## DEVELOPMENT FACILITATION TEAM

### Planning - Case Comments

**Project Number:** PR-2022-007999

**Project Name:** 1700 Unser Blvd. NW

DRAWN BY: JRM	336 Woodward Road SE
CHECKED BY:	
SCALE: AS NOTED	TITLE: TYPICAL 8'-0" H FENCE ELEVATION AND DETAILS
DATE: 11/20/2025	SHEET NO: SK001

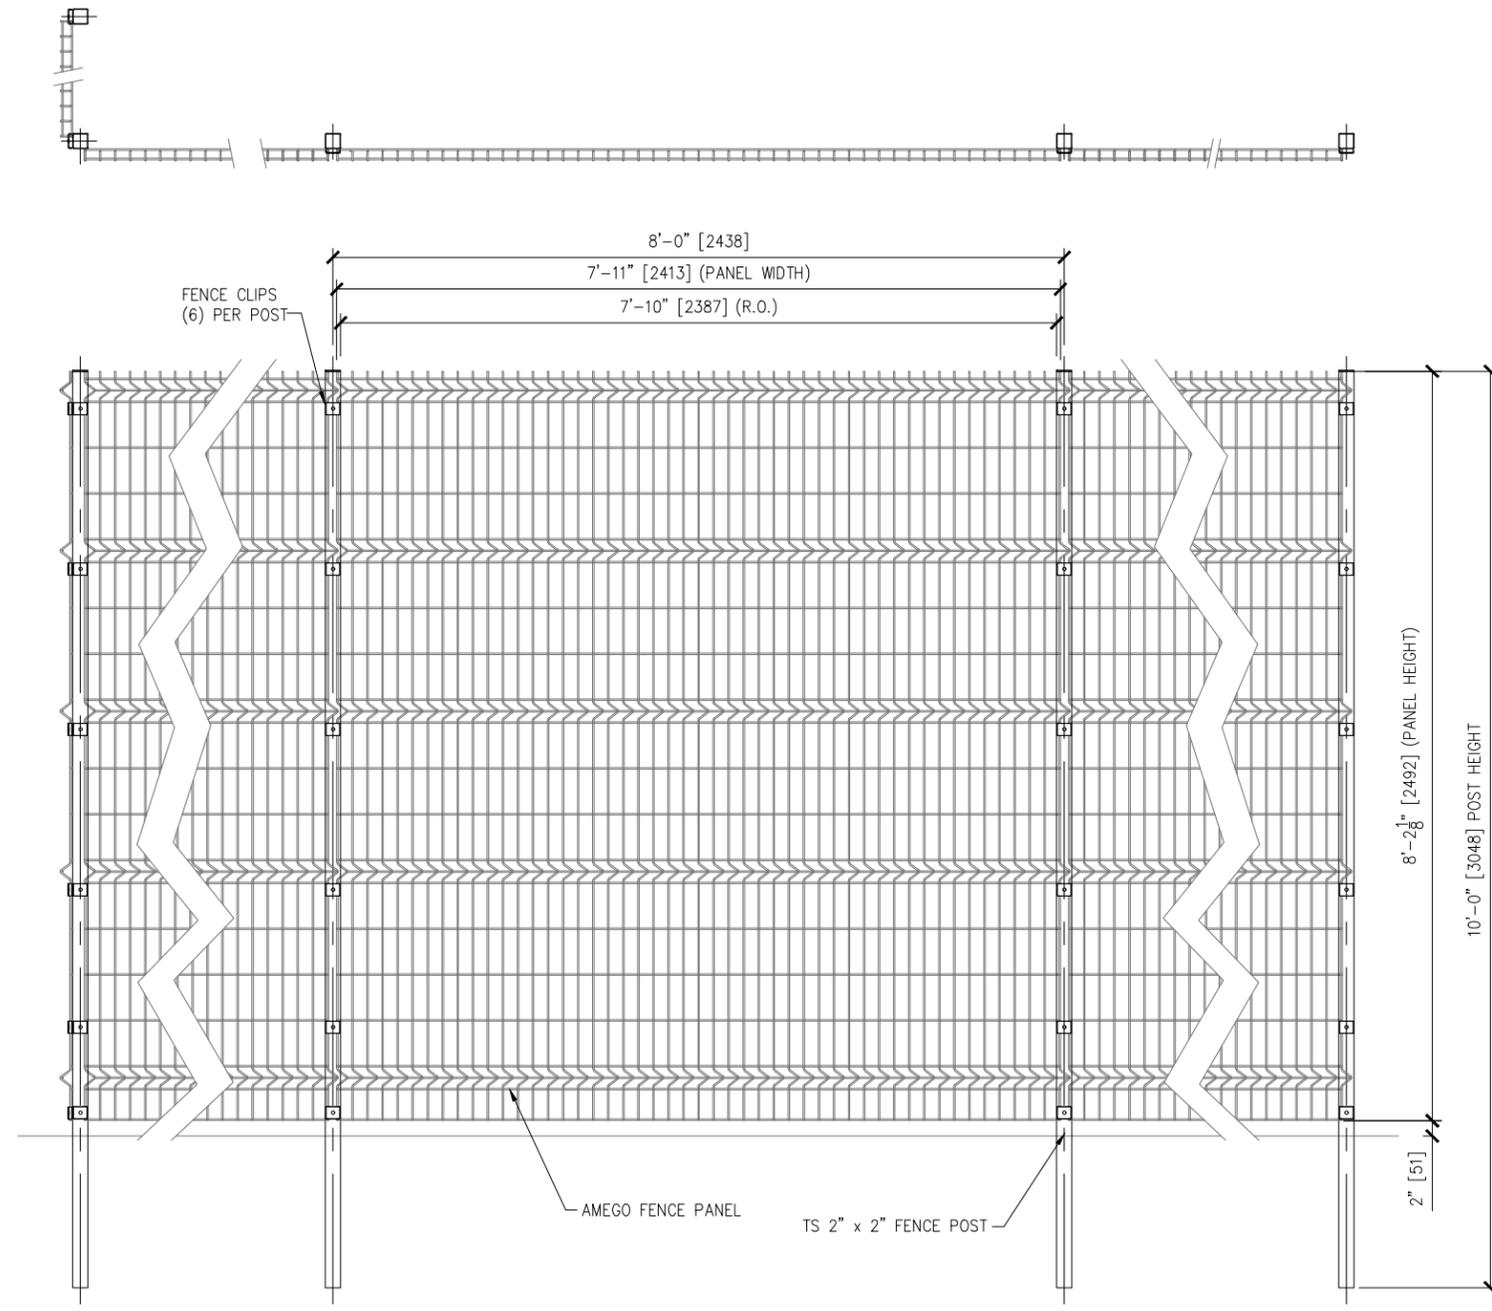
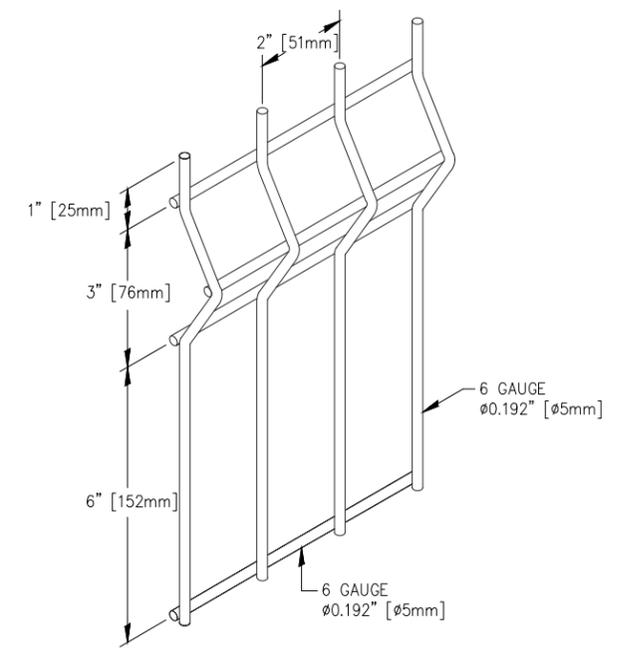
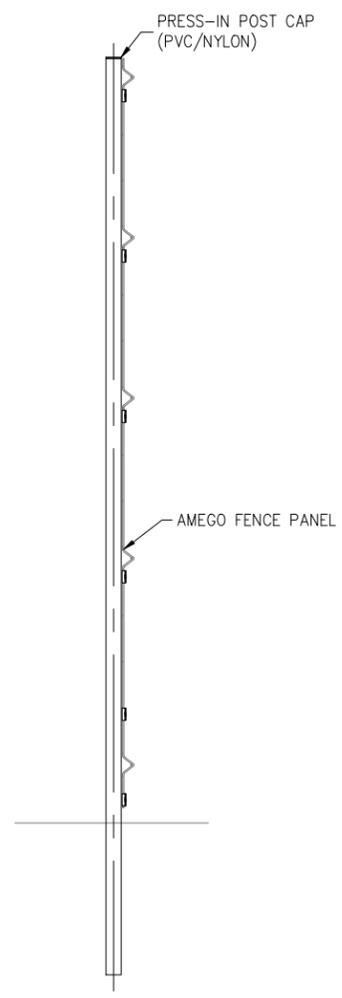
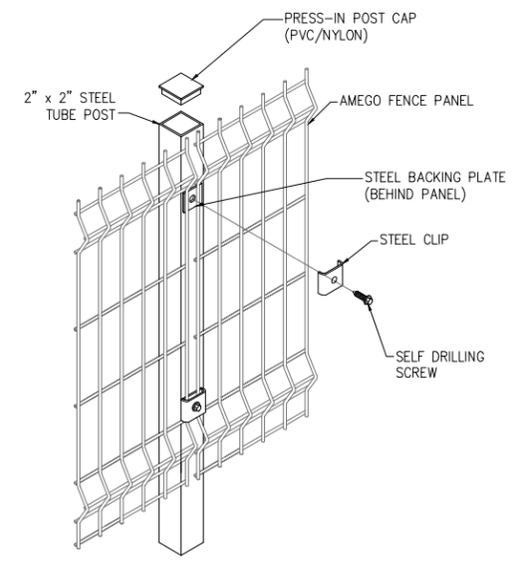
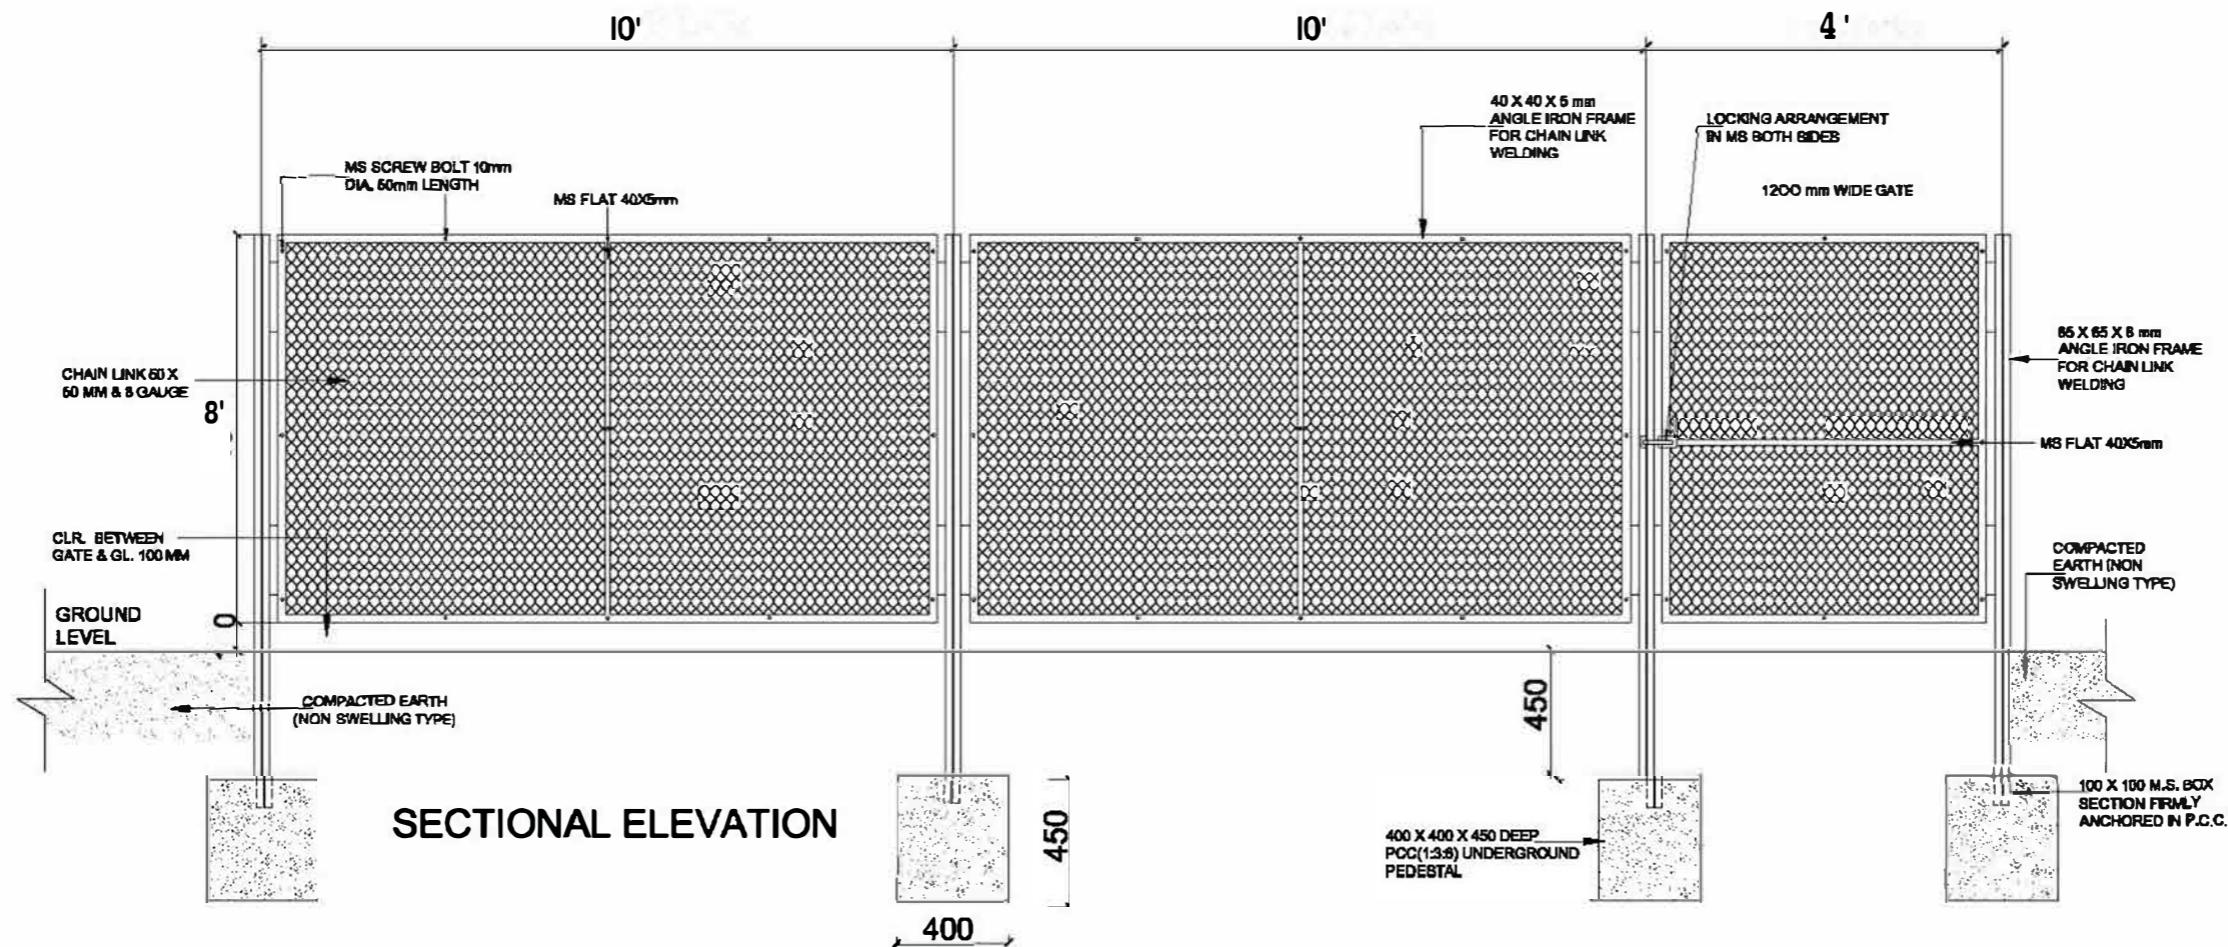
1. All walls and fences (internal and around perimeter) shall be shown on the site plan.
2. All walls and fence detail shall be shown on detail sheet for each that provide height, type/material and any screening materials (e.g. Fabric, slats).

7. Provide separate Detail Sheet for parking related barriers and signage, walls and fences, and wall signs.

**The applicant has provided an updated Site Plan that accurately reflects the location of all walls and fences on the site, including the specifications of all walls and fences on the detail sheet.**

**The applicant has provided a Detail Sheet that provides specifications for walls, fences, signs and parking related fixtures.**
